**FIVE ESTUARIES OFFSHORE  
WIND FARM**

**SCHEDULE OF CHANGES TO THE DRAFT  
DEVELOPMENT CONSENT ORDER  
(TO REVISION E, DEADLINE 4)**

Application Reference	N/A
Application Document Number	N/A
Revision	N/A
APFP Regulation:	N/A
Date	December 2024

DRAWING NUMBER: 005023882-01
 APFP Regulation: 5(2)(a)
 Sheet No: 11 of 20

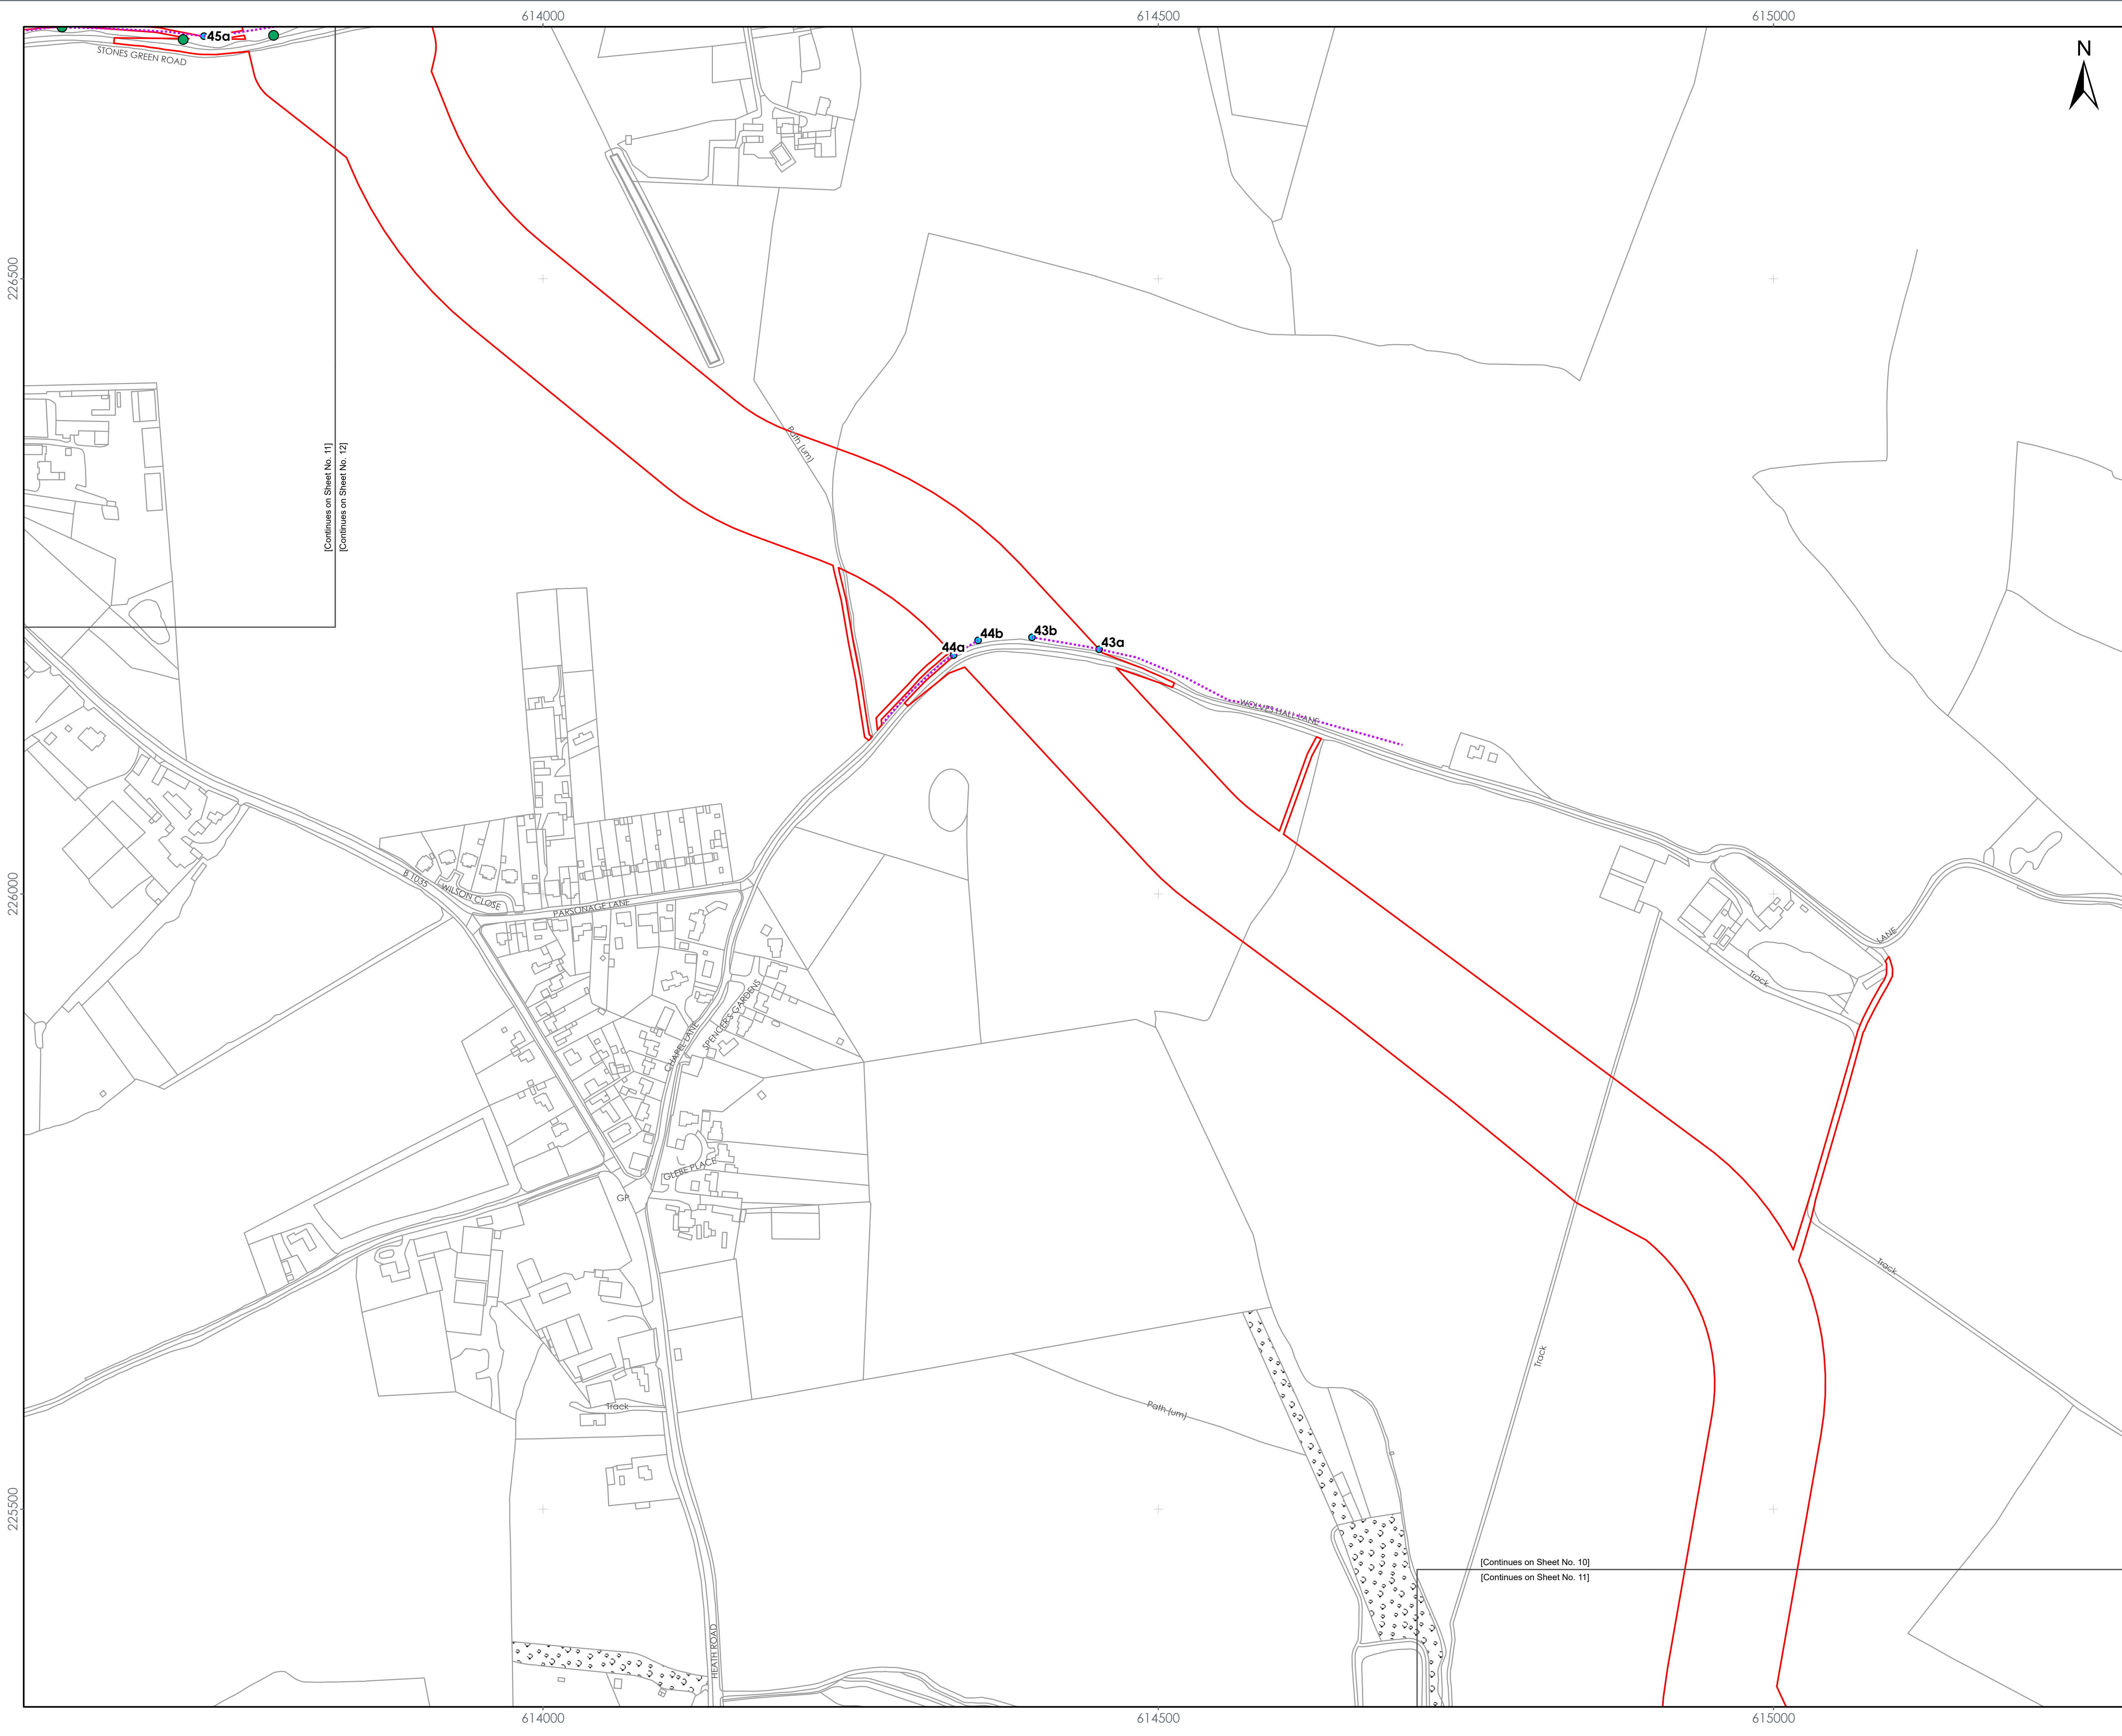
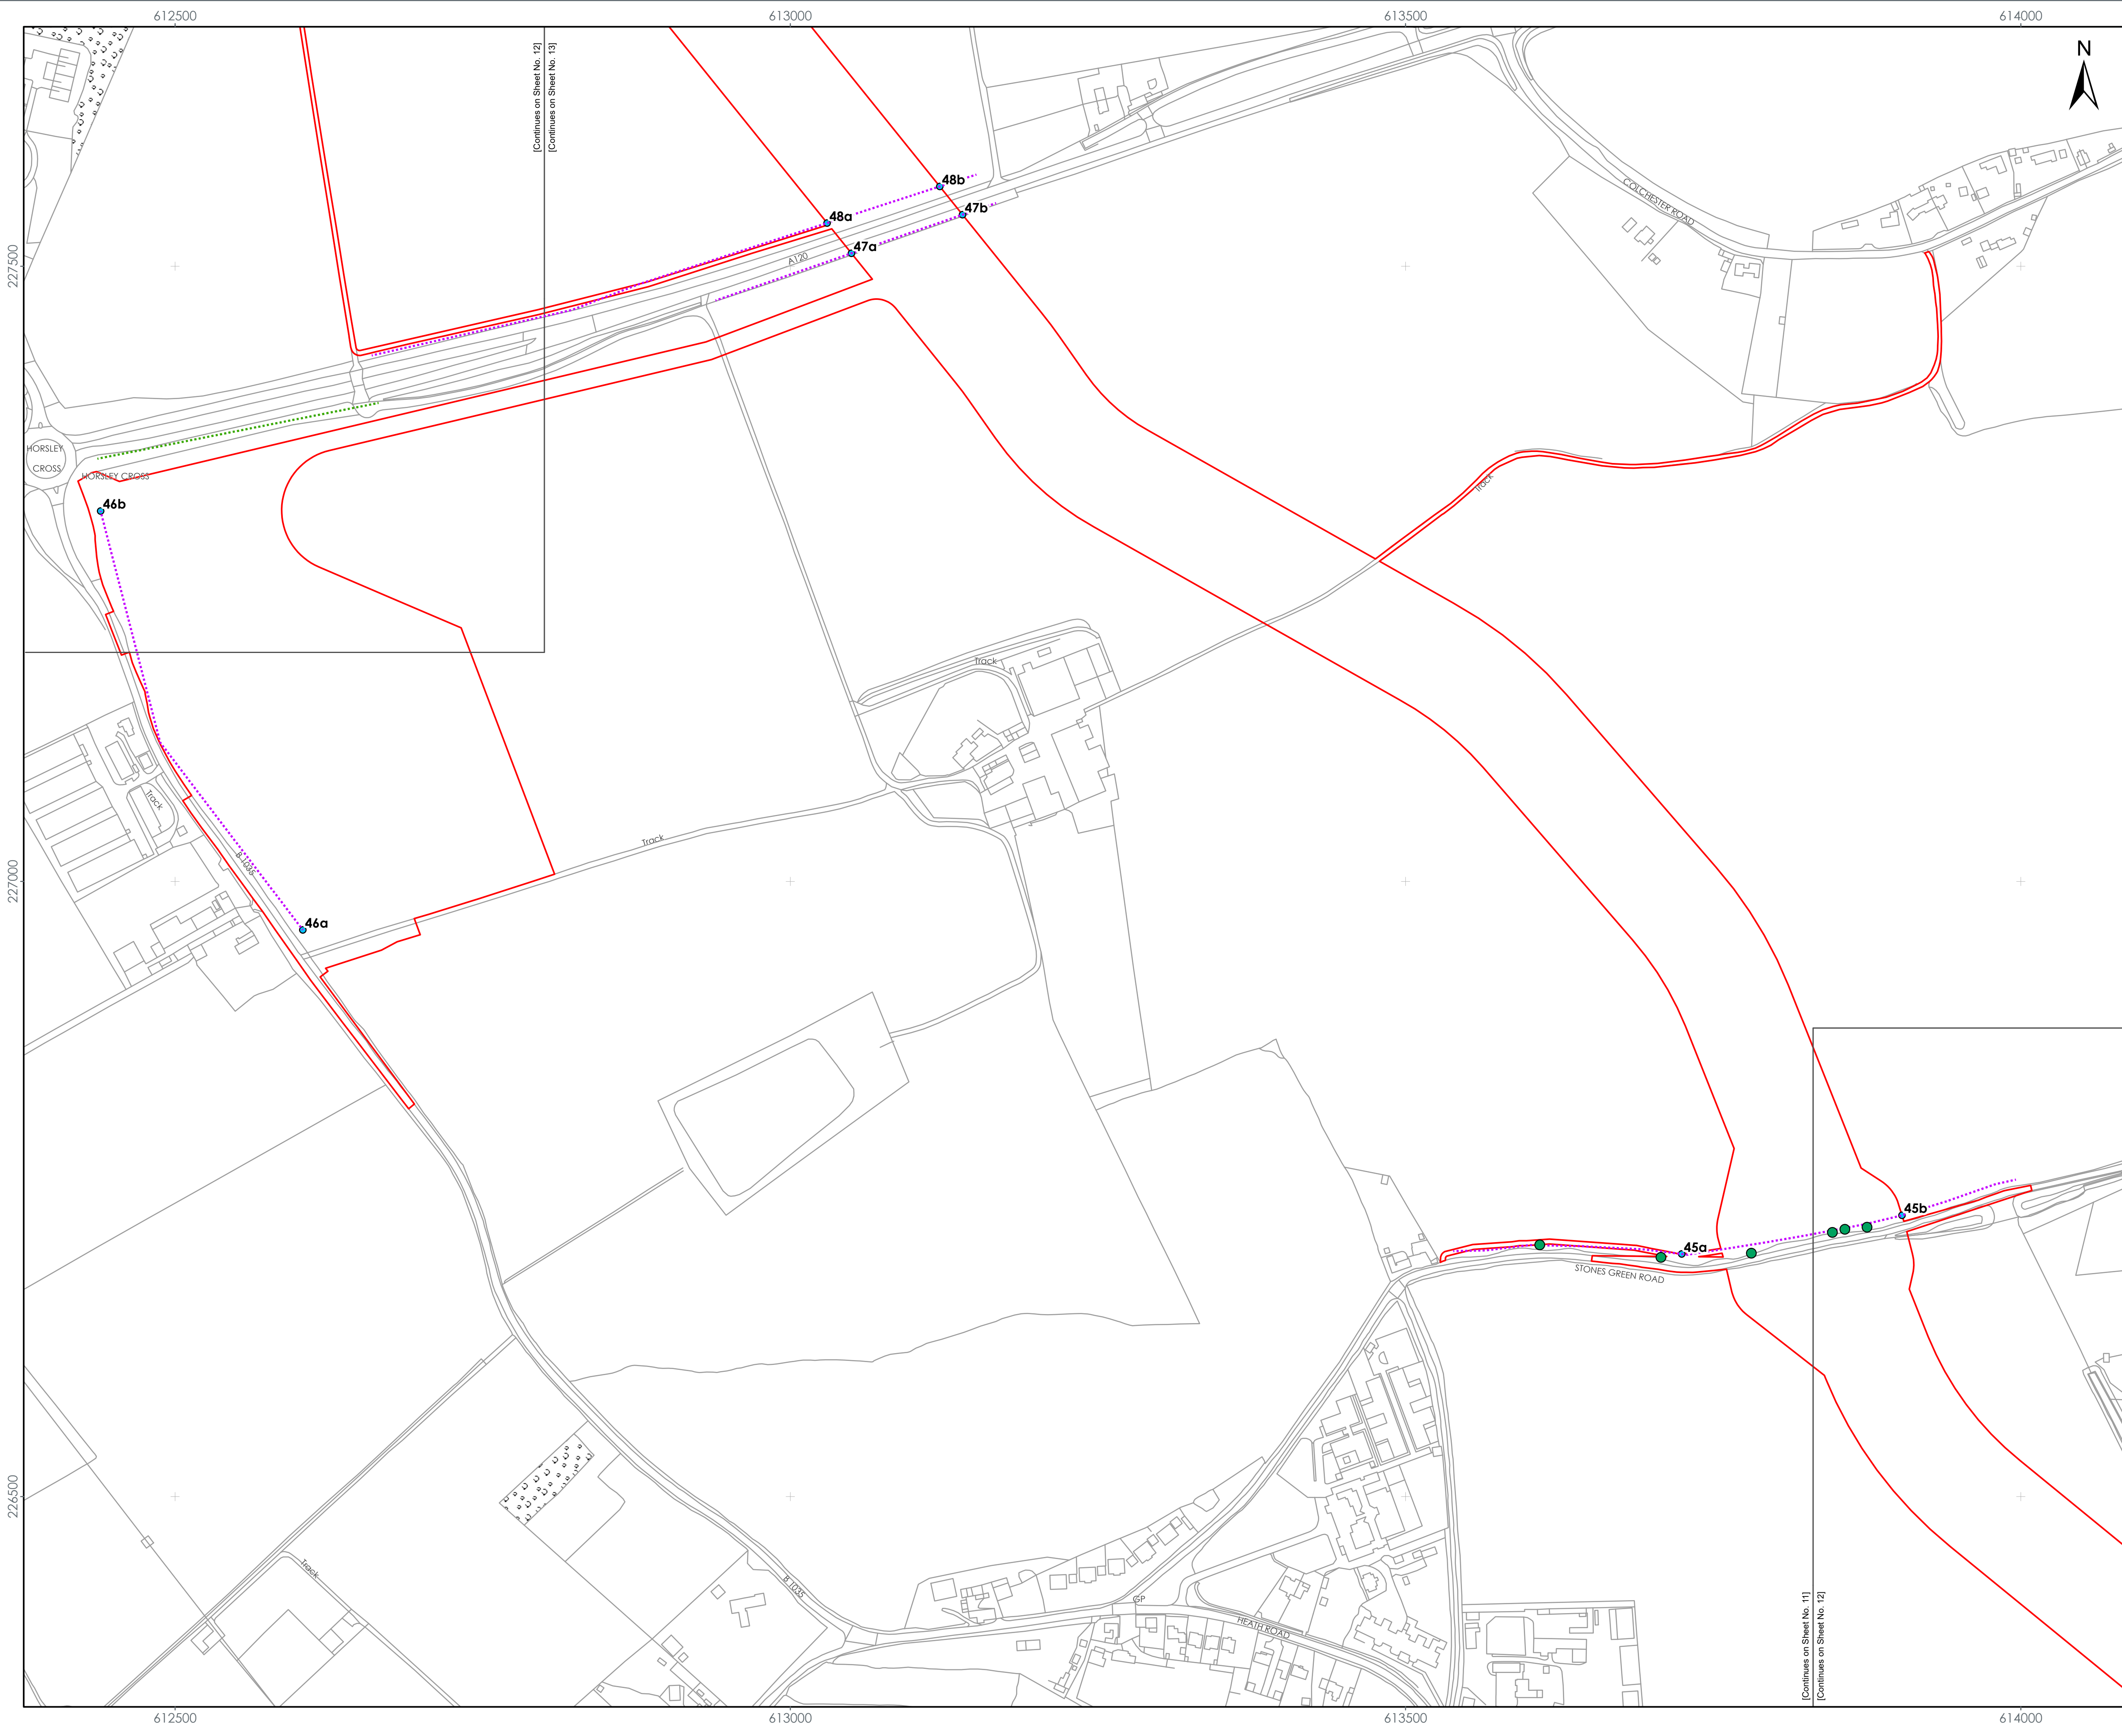
Reference	Amendment	Reason	
<b>Articles</b>			
Article 38, Trees subject to tree preservation orders	<p>Subject to paragraph (2), the undertaker must not fell, lop, prune, or cut back the roots of any tree which is the subject of a tree preservation order <a href="#">except as provided in Schedule 12 Part 1 (trees subject to tree preservation orders)</a>.</p> <p>The undertaker may fell or lop any tree within or encroaching upon the Order limits that is subject to a tree preservation order <a href="#">is not listed in Schedule 12 Part 1 (trees subject to tree preservation orders)</a> and which tree preservation order which was made after 12 March 2024, or cut back its roots, if it reasonably believes it to be necessary in order to do so in order to prevent the tree—</p>	As TPO'd trees which may need to be lopped have been identified	
Schedule 4, Traffic regulation	Part 2, Rights of way to be temporarily closed or restricted	This Prow has always been in 2 parts but was inaccurately shown on previous versions, this change corrects that
